Roadway Plans_V1.pdf Markup Summary

CLEARWAY FILING NO. 2, LOT 5

CONSTRUCTION PLANS

**STORM 1 STA 0+99.84 TO STA 6+72.07**

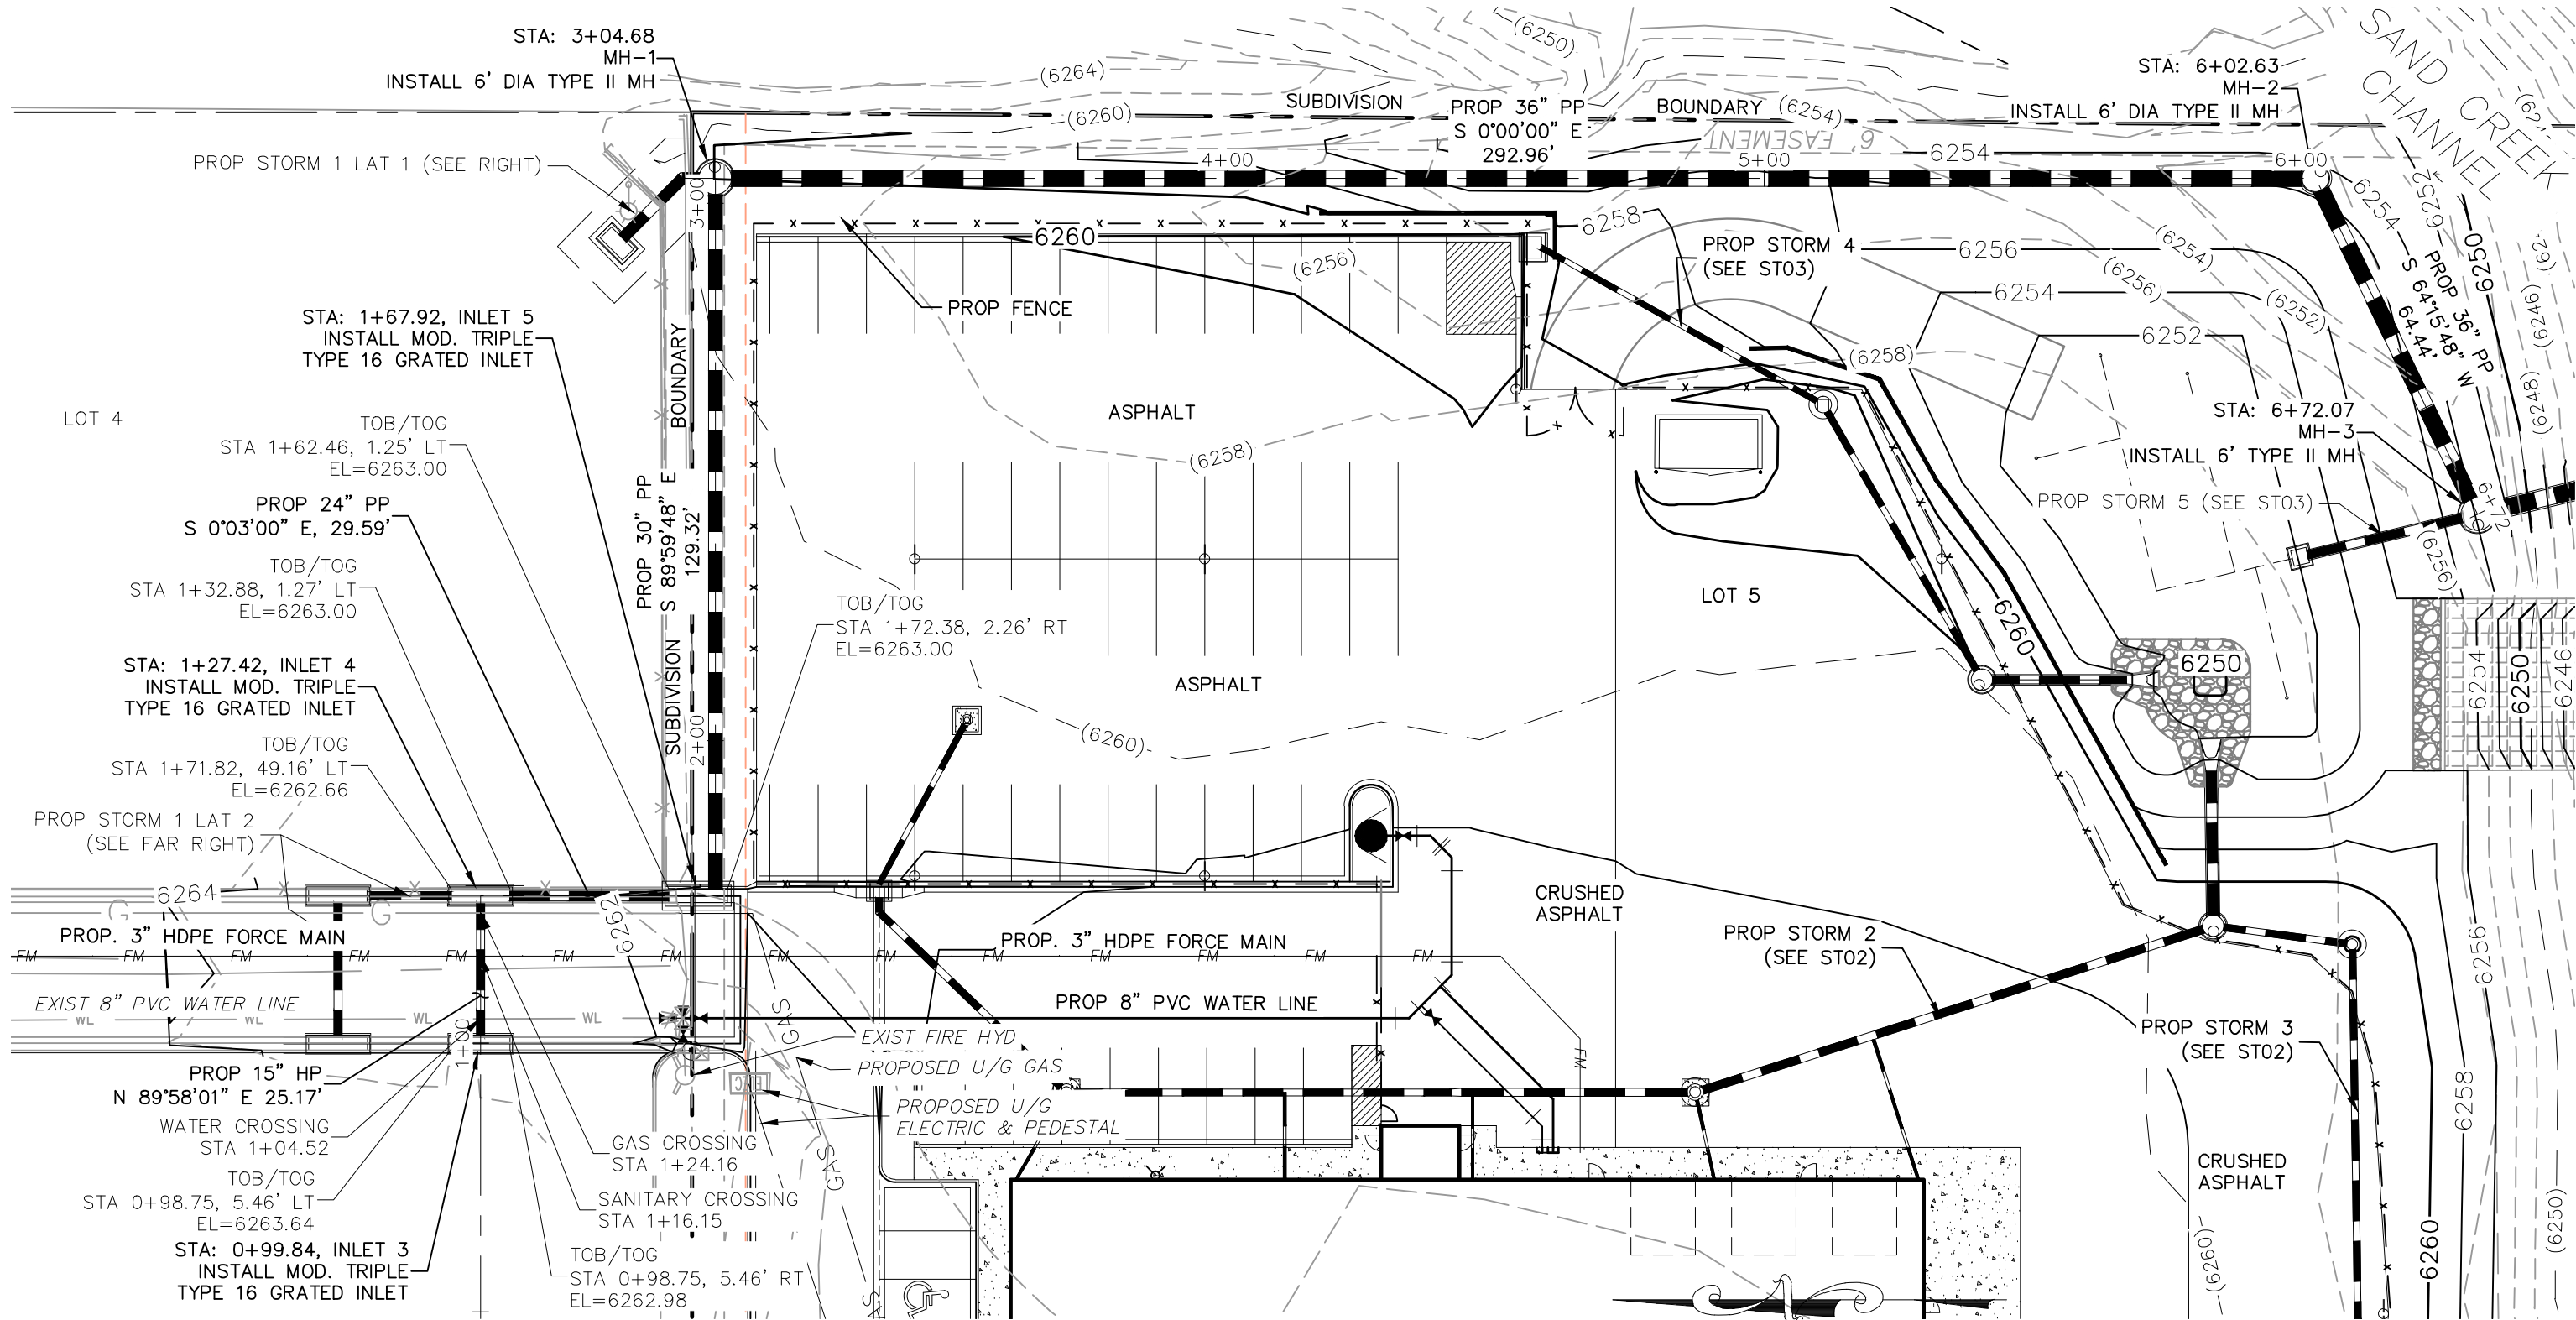
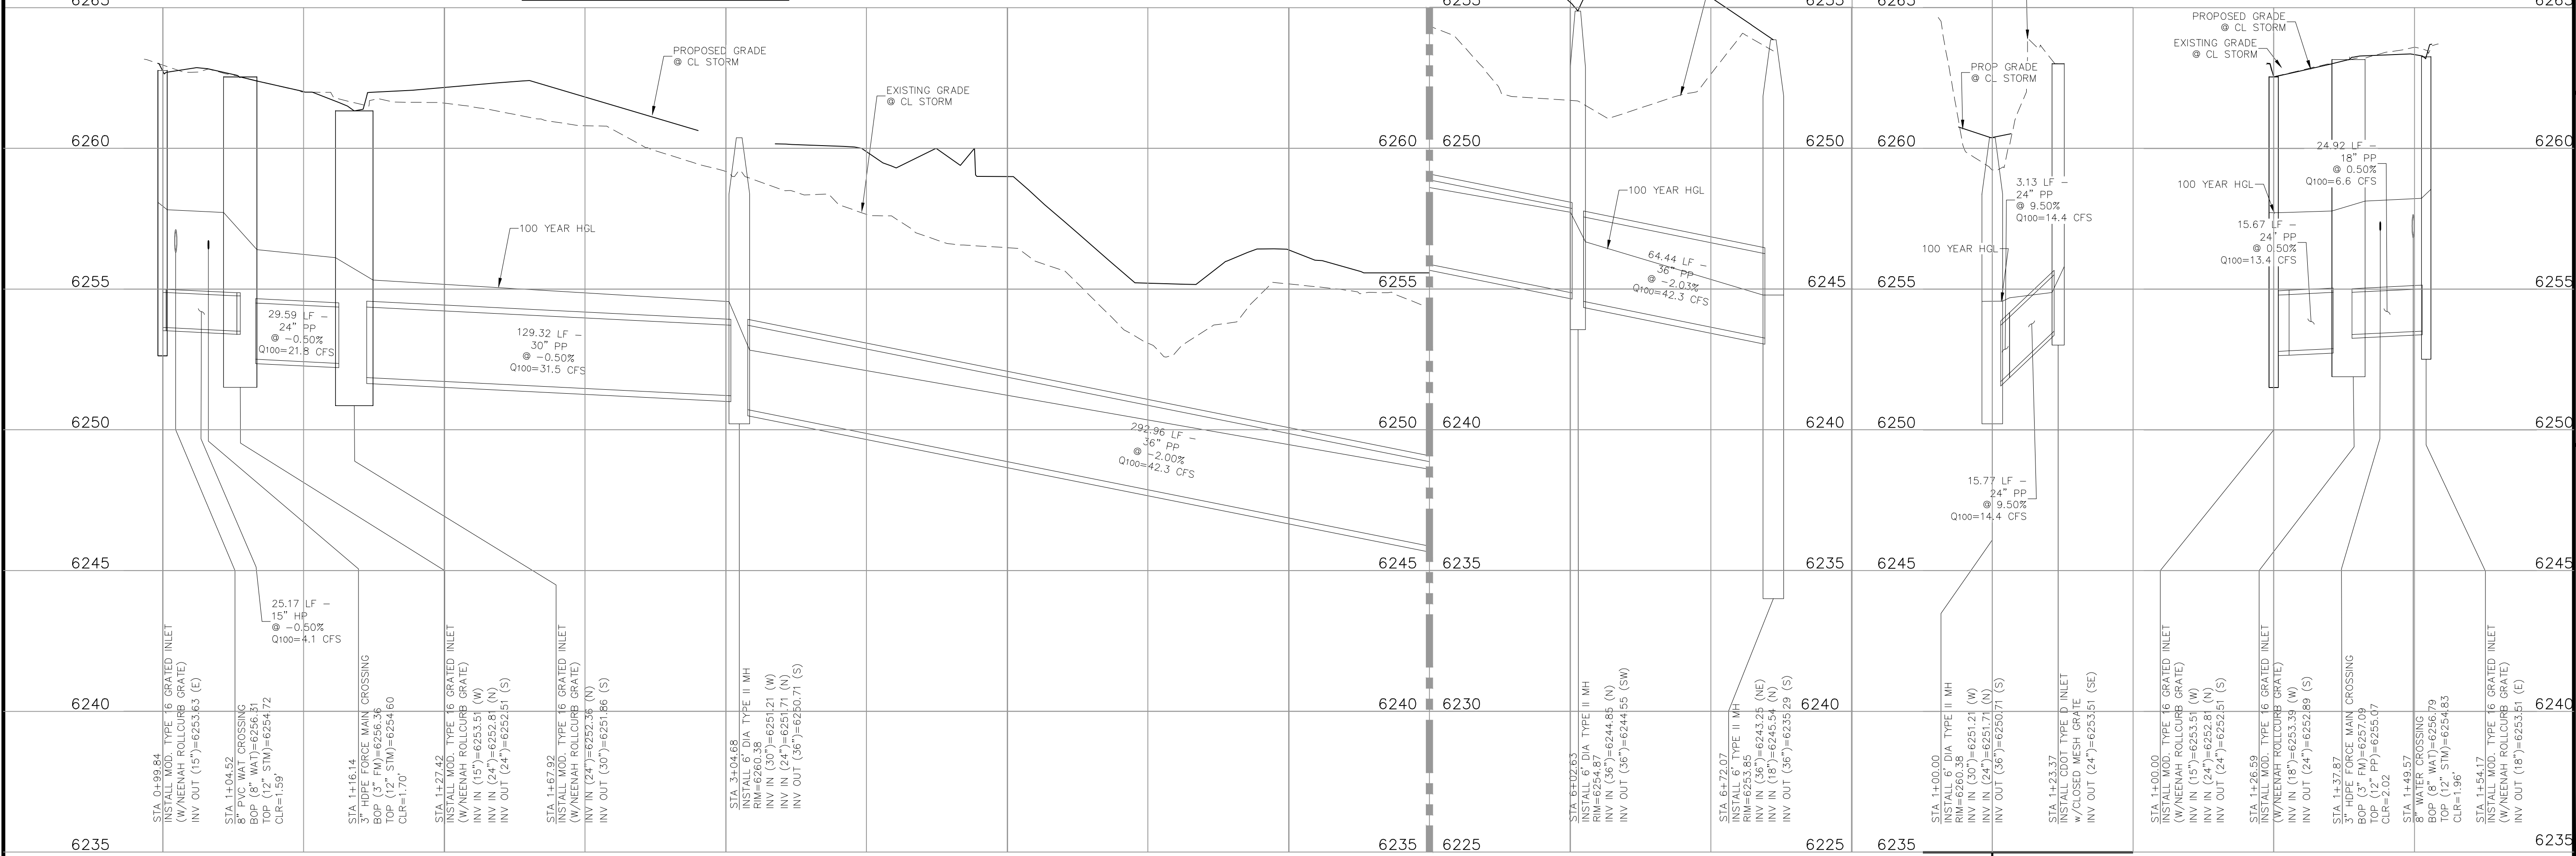
Show HGL lines on the profiles.

identify who will maintain the proposed inlets and storm sewers in the common easement

triple type 16 is indicated on the drainage report. revise.

Typical at all storm profiles.

provide vertical scale
